**WELWYN HATFIELD BOROUGH COUNCIL
EXECUTIVE DIRECTOR - PLANNING, PUBLIC PROTECTION AND GOVERNANCE**

DELEGATED APPLICATION

Application No: 6/2020/1010/FULL
Location: 2 De Havilland Close Hatfield AL10 0DR
Proposal: Conversion of existing single dwelling into two dwellings
Officer: Ms Lucy Hale

SCALE: 1:50
 DATE: Mar 2016
 JOB/DRG. No.: 2016-054C
 SHEET 2 OF 2

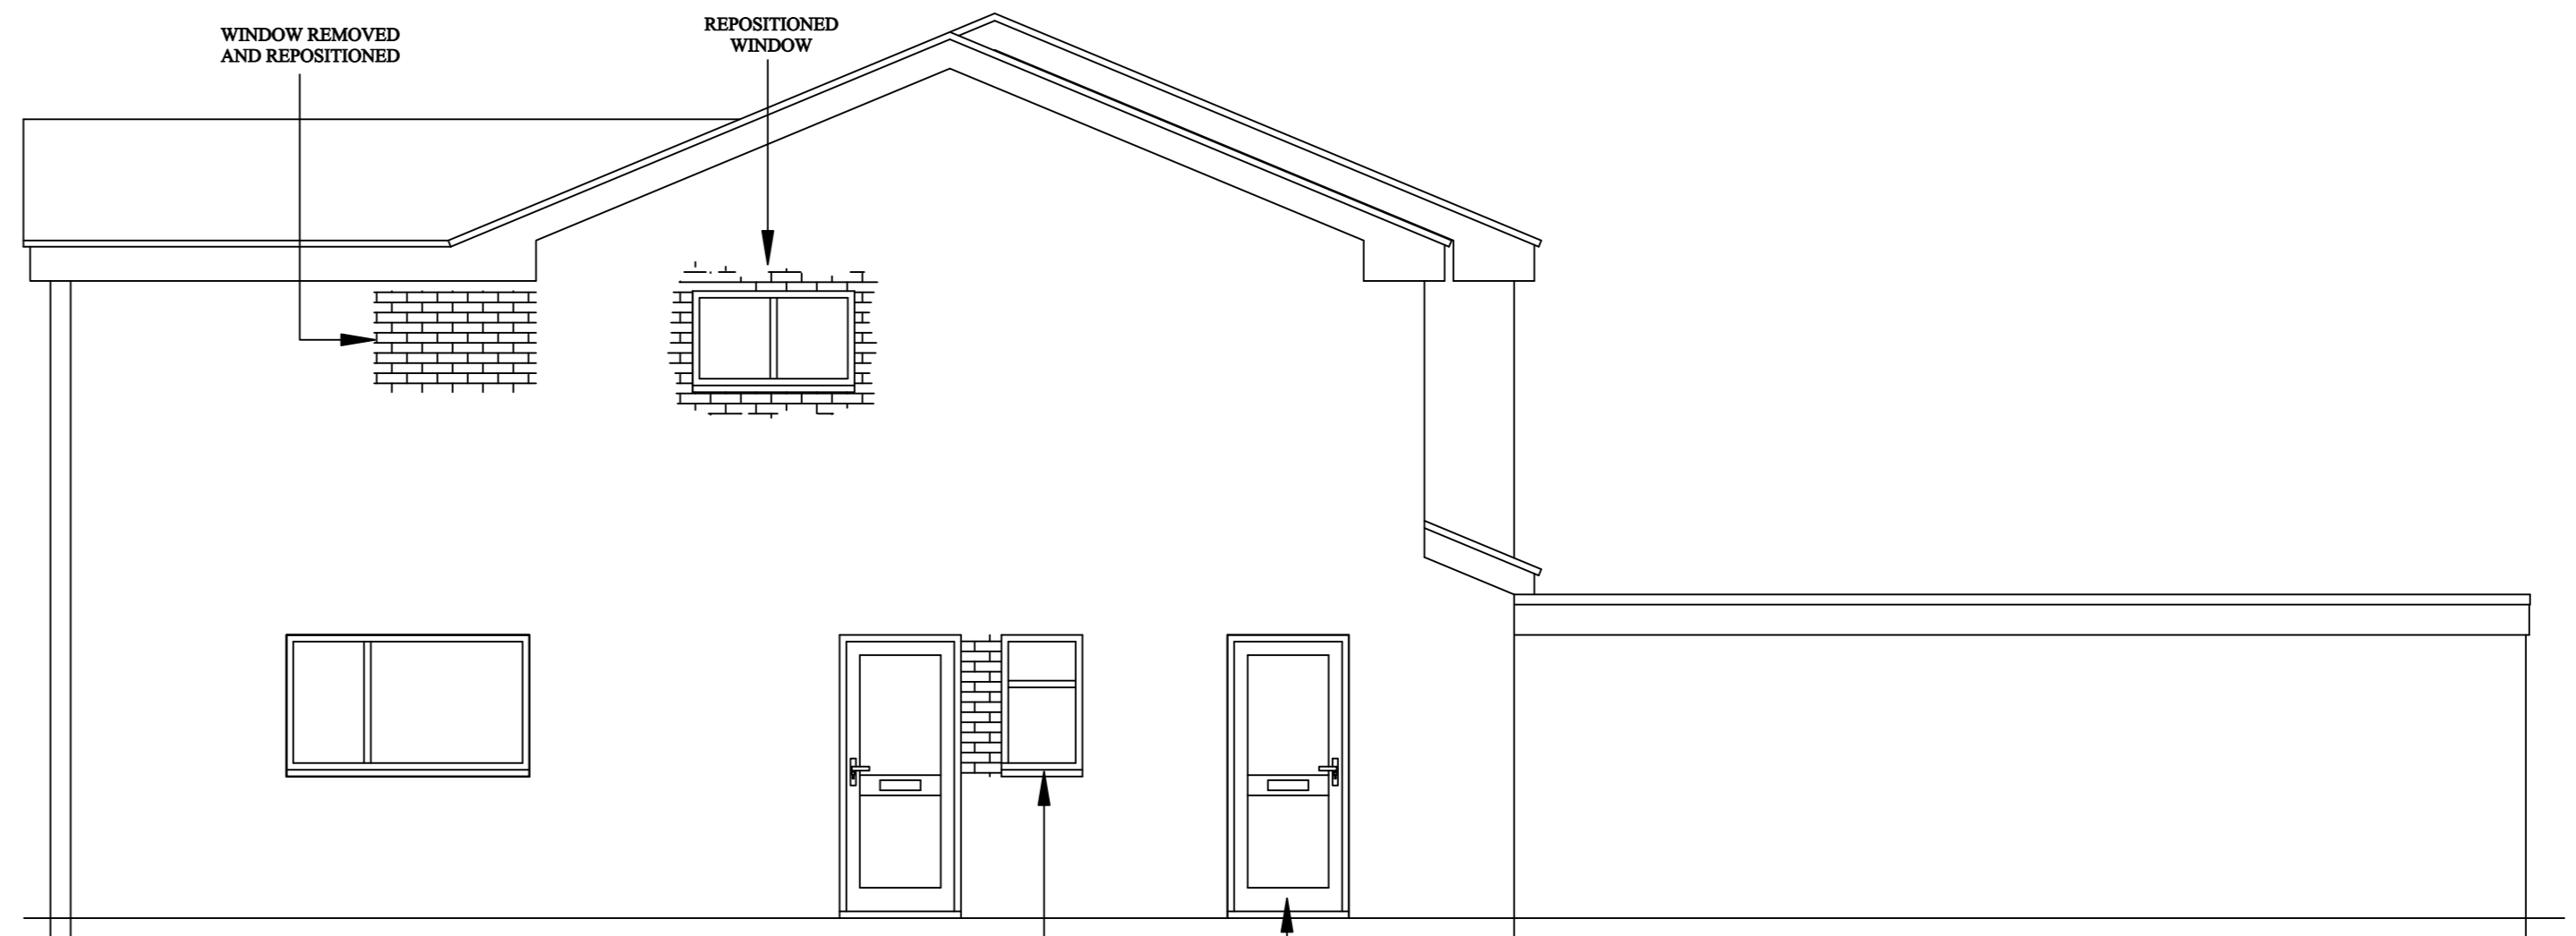
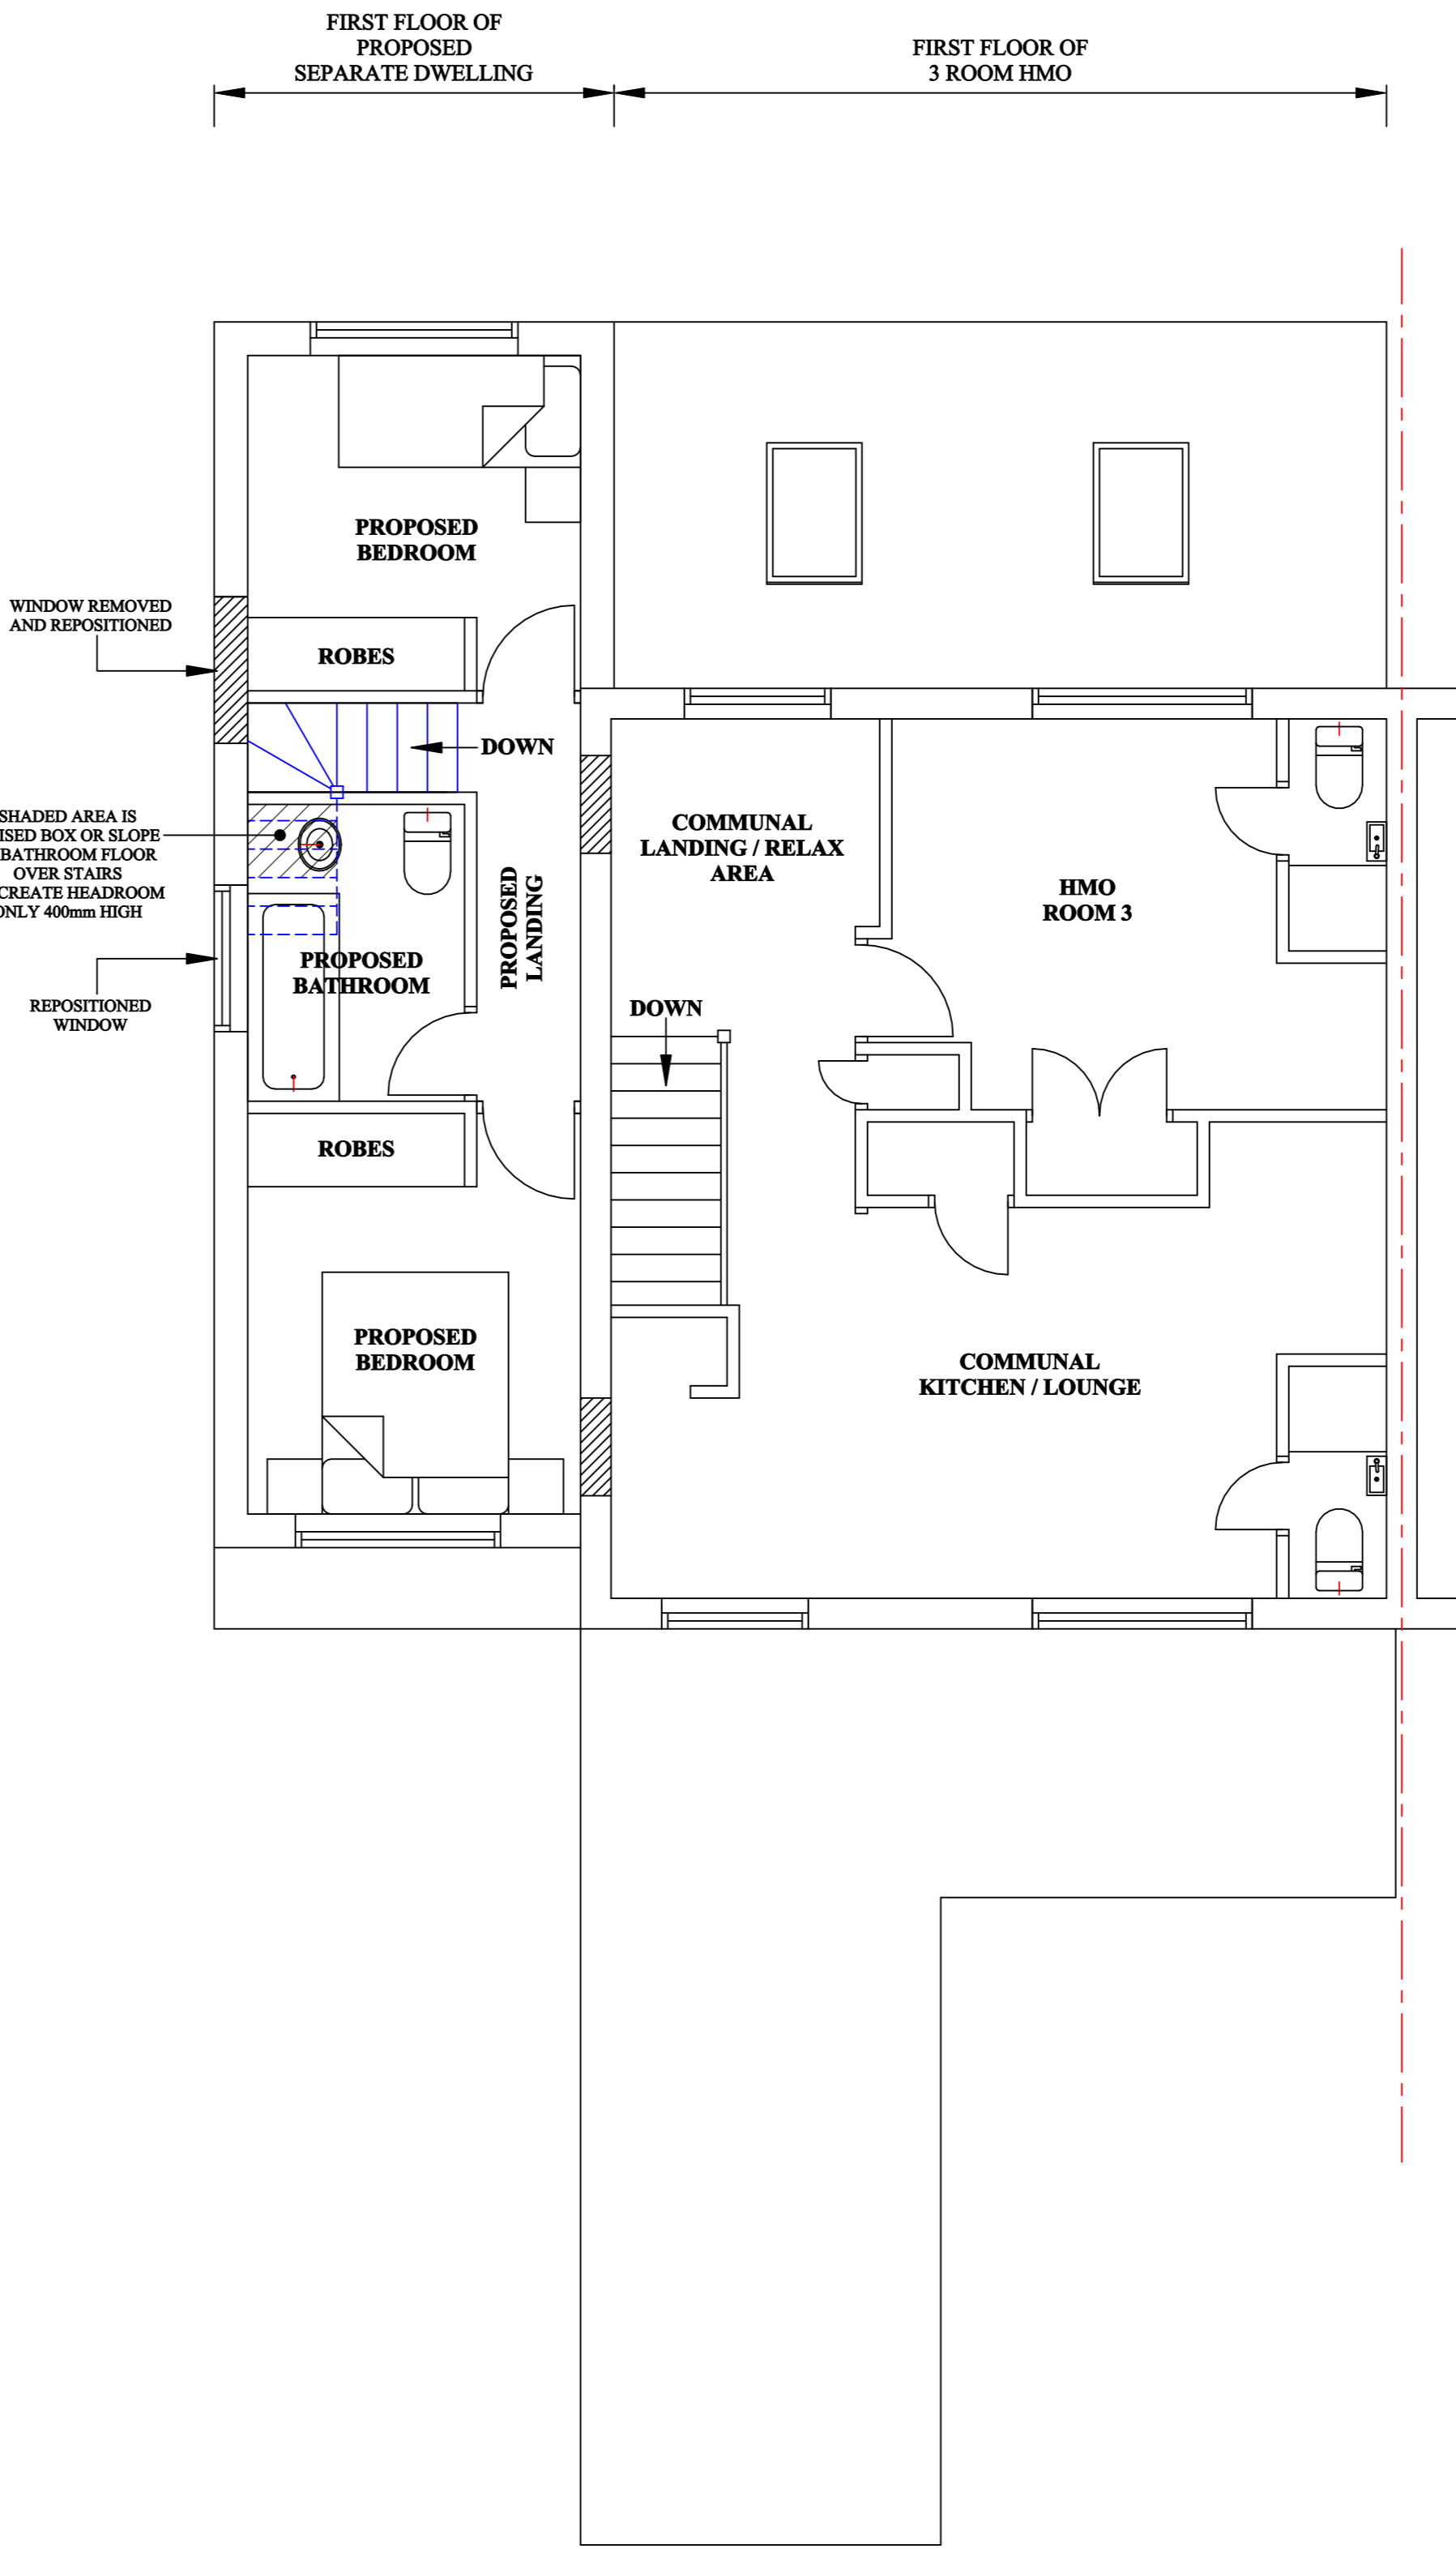
Comment (if applicable):	
<p>No objections have been received. There would be no increase in the size of the building is proposed, consequently, there would be no impact on neighbours in terms light or outlook. In terms of privacy, it is considered reasonable again to condition the relocated window at first floor to be to be obscure glazed and fixed below a height of 1.7m above the internal floor level.</p> <p>In addition, to protect the amenity of neighbouring occupiers, it would be reasonable to impose a planning condition withdrawing permitted development rights enabling the Local Planning Authority to retain control over the enlargement or alteration of the proposed new dwelling (Class A) and the enlargement of consisting of an addition or alteration to its roof (Class B) in line with planning permission 6/2016/0616/FULL.</p>

5. Any upper floor window located in a wall or roof slope forming a side elevation of the building hereby approved must be obscure-glazed and non-opening unless the parts of the window which can be opened are more than 1.7 metres above the floor of the room in which the window is installed, and shall be retained in that form thereafter.

JOB/DRG. No:-
2016-064C

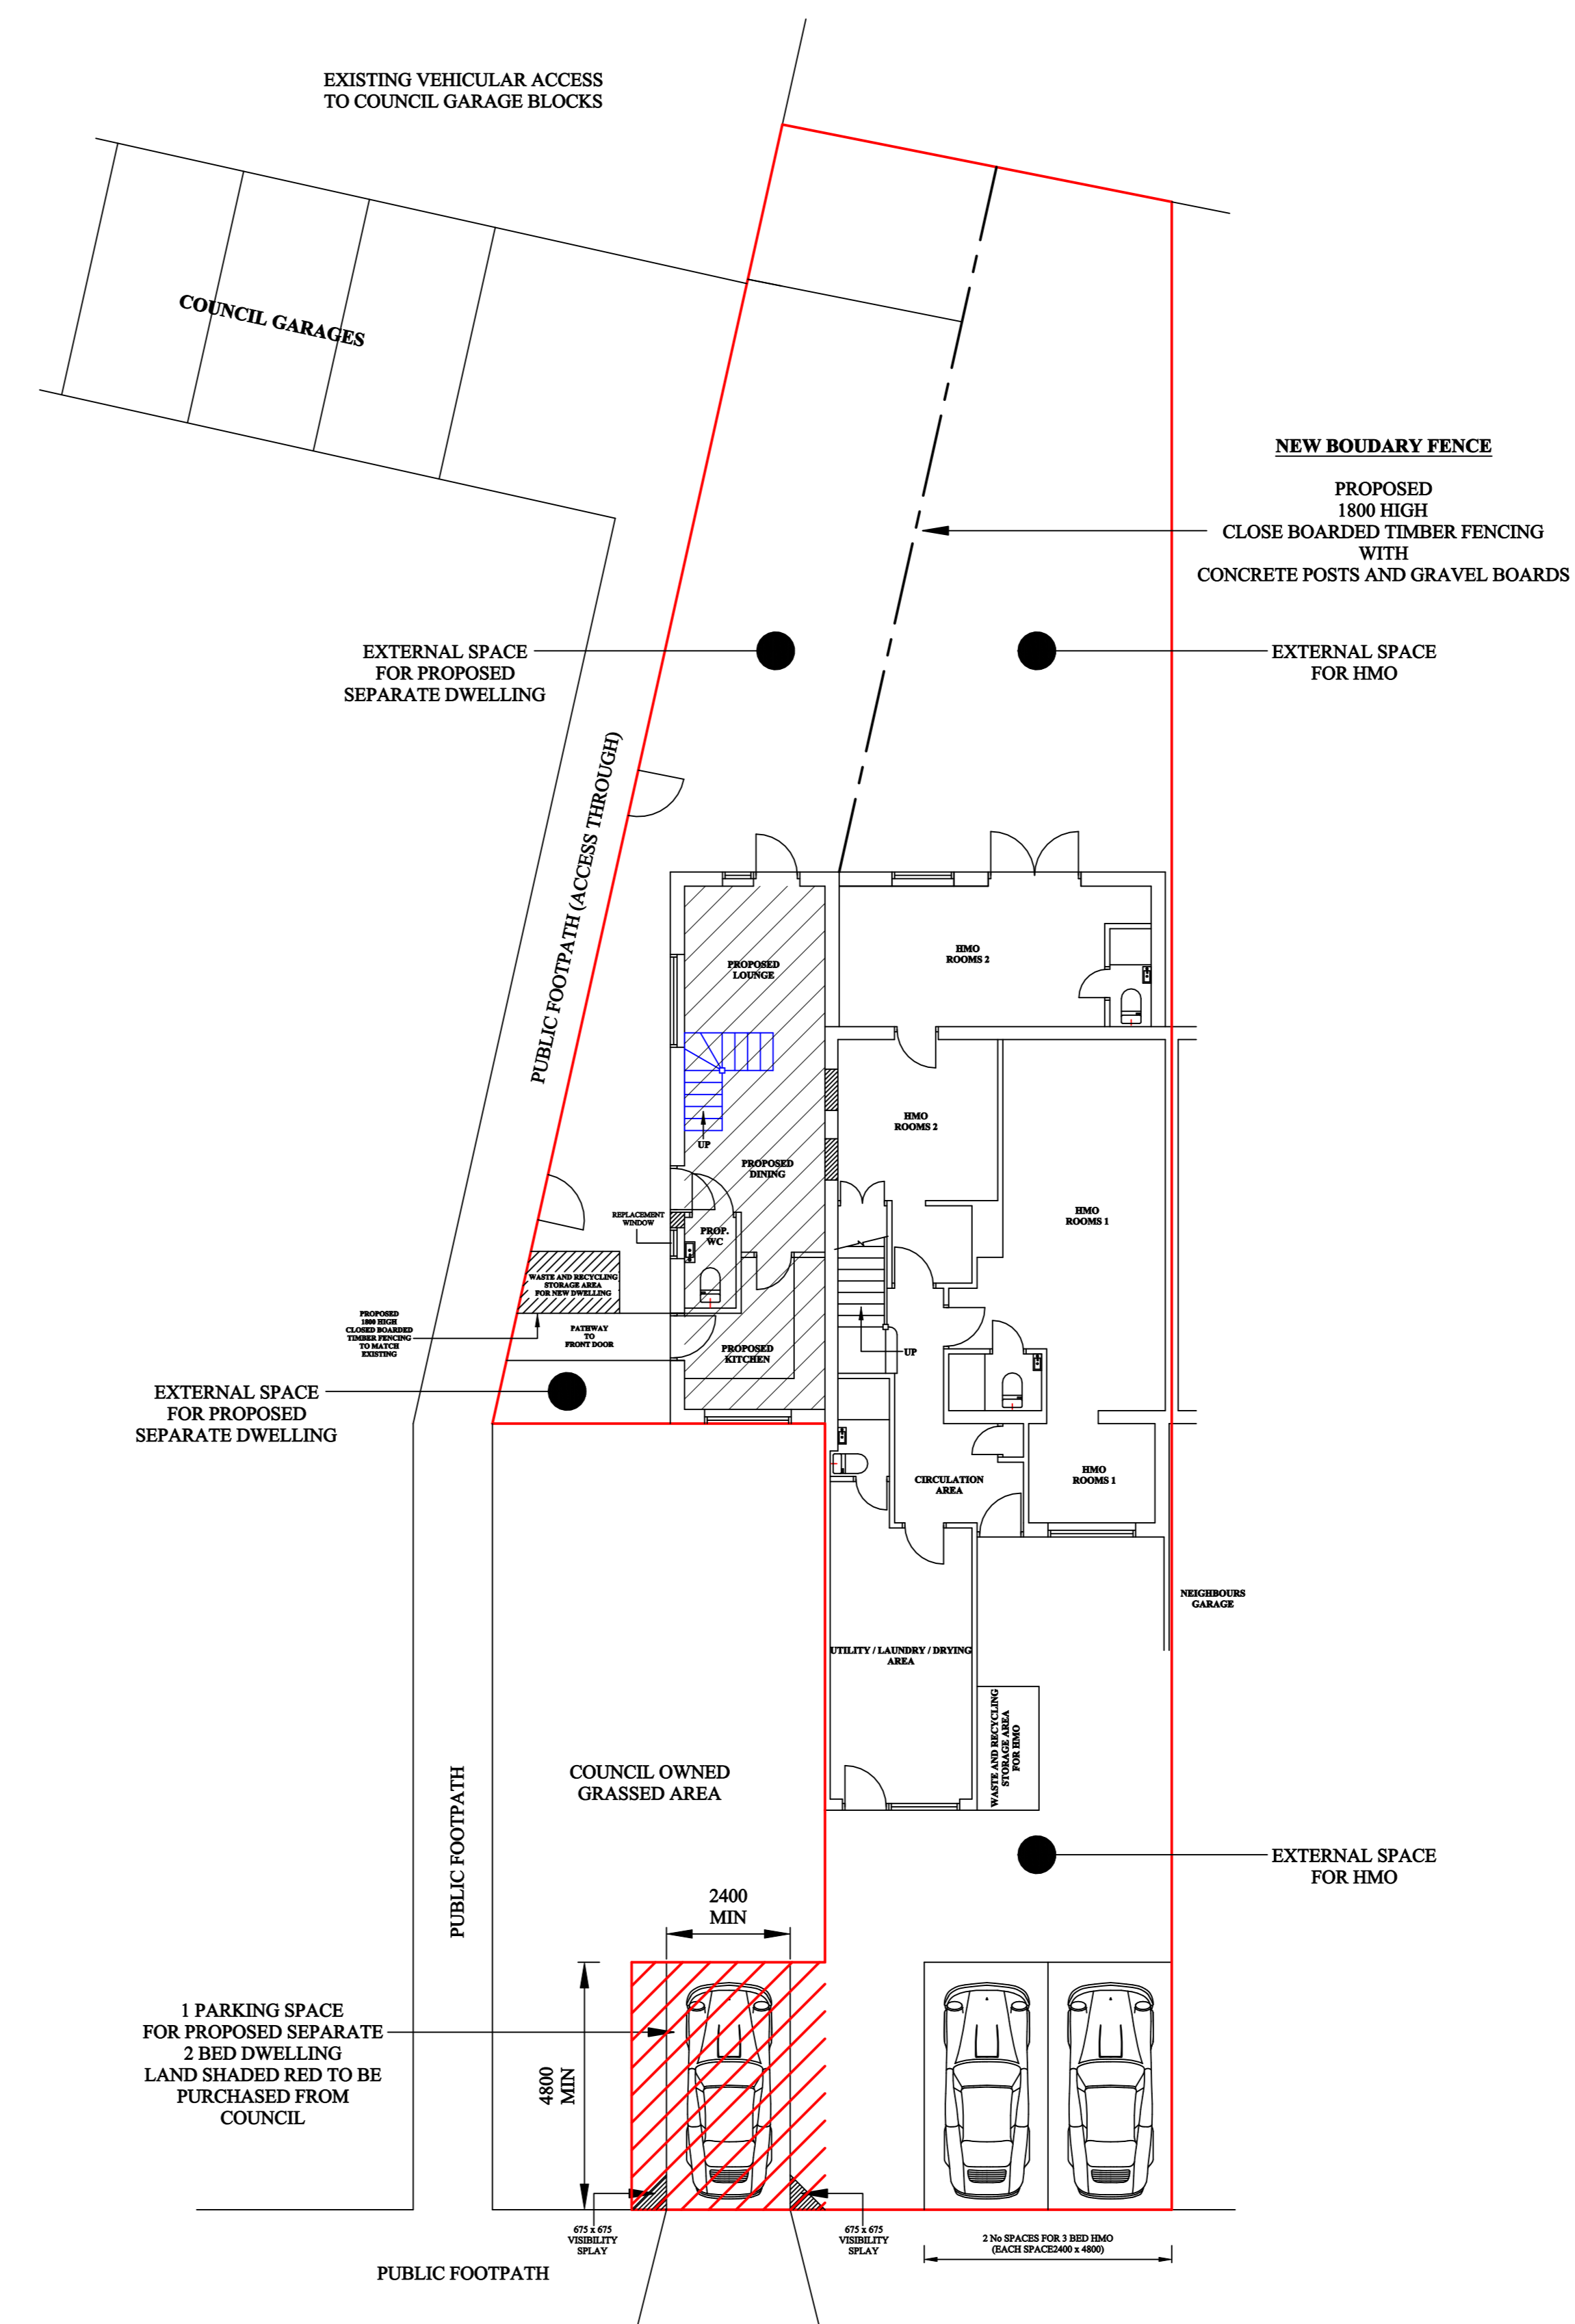
Concerns have been raised by Hatfield Town Council and the Council's Parking Services team regarding the congestion and parking pressures in the road.

One additional off-street car parking spaces is proposed to the front of new dwelling which is acceptable for a two bedroom property in this location. The parking arrangements for the existing property are unaffected by the proposal. The Highway Authority previously commented on the proposal and considered that visibility from the proposed access would be acceptable and that the proposal is unlikely to have a material impact on the local and wider road network.

4. The area set aside for car parking on drawing number 2016-064C shall be laid out surfaced and marked out before the buildings hereby permitted are first occupied and shall be retained permanently thereafter for the parking of vehicles for residents/occupiers of the development permitted and shall not be used for any other purpose.
